**KIRKLEES METROPOLITAN COUNCIL
INVESTMENT & REGENERATION SERVICE**

DELEGATED DECISION TO DETERMINE APPLICATIONS FOR LISTED BUILDING CONSENT

Reference No:	2025/65/90554/E
Site Address:	14, Station Road, Shepley, Huddersfield, HD8 8DG
Description:	Listed Building Consent for alterations to front elevation, to include replacement windows, door, lime pointing and renewal of exterior window surround paint (within a Conservation Area)
Recommending Officer:	Faiza Bano

DECISION – Listed Building Consent - Granted

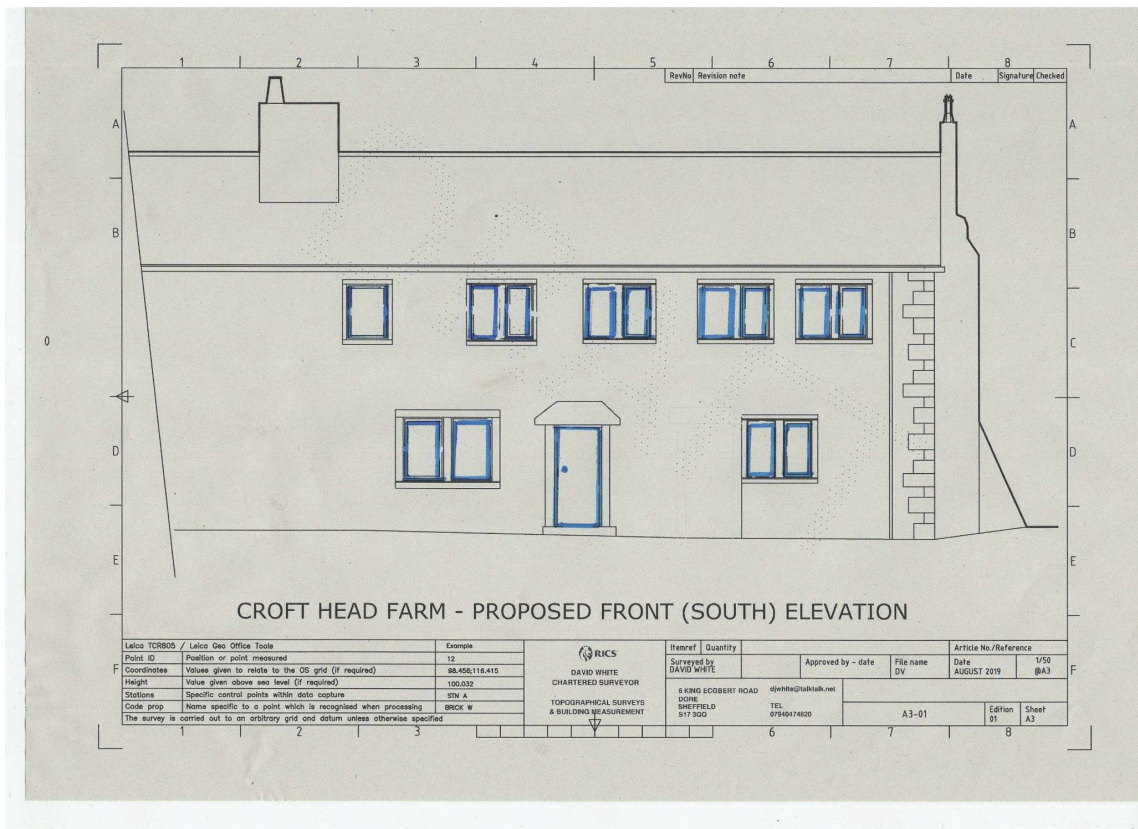
The plans indicate that the windows to be replaced are situated across the front elevation. The existing windows, constructed from modern UPVC and wooden casement windows, will be replaced with heritage steel slim-framed Crittall windows in matt black.

- **Slimlite Steel Windows:** The new Slimlite steel windows will be installed as fixed light or side-hung casements with a black painted finish, including black spacer bars, to maintain the heritage aesthetic.

- **Traditional Window Hardware:** Opening casements will feature butt hinges and traditional window stays, ensuring that friction hinges are not used, thus preserving the historical character of the windows.

- **Window Frame Positioning:** All new window frames will be set back in the reveal by 100-125mm, rather than being fitted flush with the external wall, to maintain the traditional appearance and depth of the windows.

- **Trickle Vents:** Visible trickle vents will not be permitted, ensuring that the windows retain their clean, unobstructed look.
- **Obscured Glazing:** Any obscured glazing will have a plain etched finish rather than patterned glass, maintaining a consistent and understated appearance.

5. The new Slimlite steel windows shall be installed as fixed light or side-hung casements with a black painted finish, including black spacer bars.

6. Opening casements shall feature butt hinges and traditional window stays; friction hinges shall not be permitted.

7. All new window frames shall be set back in the reveal by 100-125mm and not fitted flush with the external wall.

8. Visible trickle vents shall not be permitted.

9. Any obscured glazing shall have a plain etched finish and not be in patterned glass.
